ExQ1: 21 April 2021

East Suffolk Internal Drainage Board Response

Response	The ESIDB is aware that further modelling work for Sizewell Link Road is being undertaken. The ESIDB would like to reserve further comment until this has been shared with the ESIDB.
FR.1.74	Environment Agency, Suffolk County Council, East Suffolk Council, East Suffolk Internal Drainage Board	Outline Drainage Strategy (ODS) [APP-181] Provide any comments you have on the coverage and content of the ODS at this stage.

Plate 3.5: Site plan showing Water Management Zone catchment areas

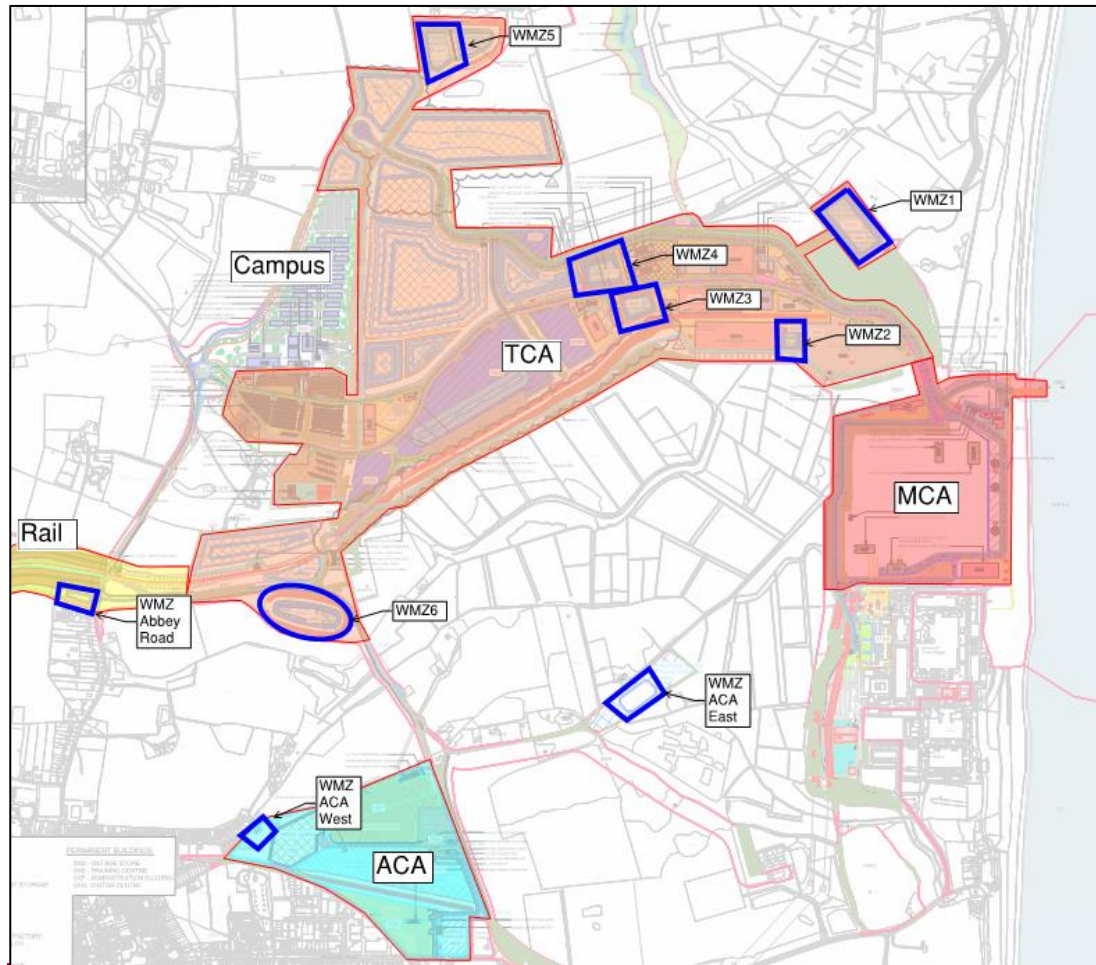
Response	Main Development Site (MDS) APP-181 provides some details on the Main Development Site (MDS) construction surface water drainage strategy. Whilst indicative Water Management Zones (WMZs) have been identified, insufficient detail has been provided regarding how surface water will be managed in each WMZ. The ESIDB would also highlight that no details have been provided detailing how surface water will be managed during the operation of the proposed development. Whilst part of the site will be subject to a nuclear safety case and will therefore require a different approach, other areas must be demonstrated to comply with national and local policy, guidance, and best practice. Main Development Site (MDS) & Associated Development Sites (ADS) To date, no supporting information has been provided to demonstrate that proposed attenuation features are sized sufficiently to manage the required attenuation volumes (which also have not been quantified). Additionally, the ODS has not been evidenced by infiltration testing (both where infiltration is proposed and where it has been discounted in favour of a discharge to a watercourse). As the viability of the ODS is not supported by infiltration testing, the impact of the ODS on the surrounding environment cannot be fully assessed.
